September 29, 2020

Site: Amaran Senior Living, 9100 Holly Ave. NE

Re: Drainage Ordinance (14-5-2-1) Violations for Erosion and Sediment Control

CONSTRUCTION ENTRANCE STABILIZATION
SCALE: 1" = 10'-0" HORIZ.

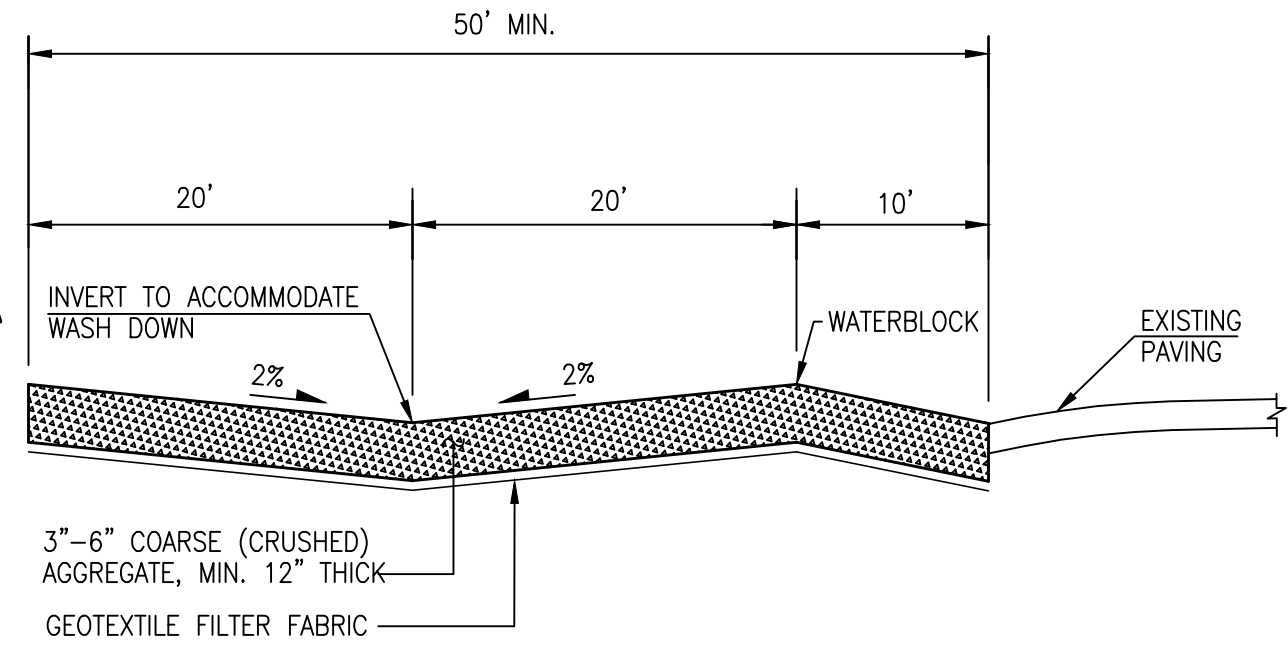
1. BMPs need maintenance (Construction Entrance)

1. Ensure that all stormwater controls (BMPs) are maintained and remain in effective operating condition during permit coverage per CGP 2.1.4. If at any time you find that a stormwater control needs routine maintenance, you must immediately initiate the needed maintenance work, and complete such work by the close of the next business day. When the problem requires a new or replacement control or significant repair, install the new or modified control and make it operational, or complete the repair, by no later than seven (7) calendar days from the time of discovery per CGP 5.
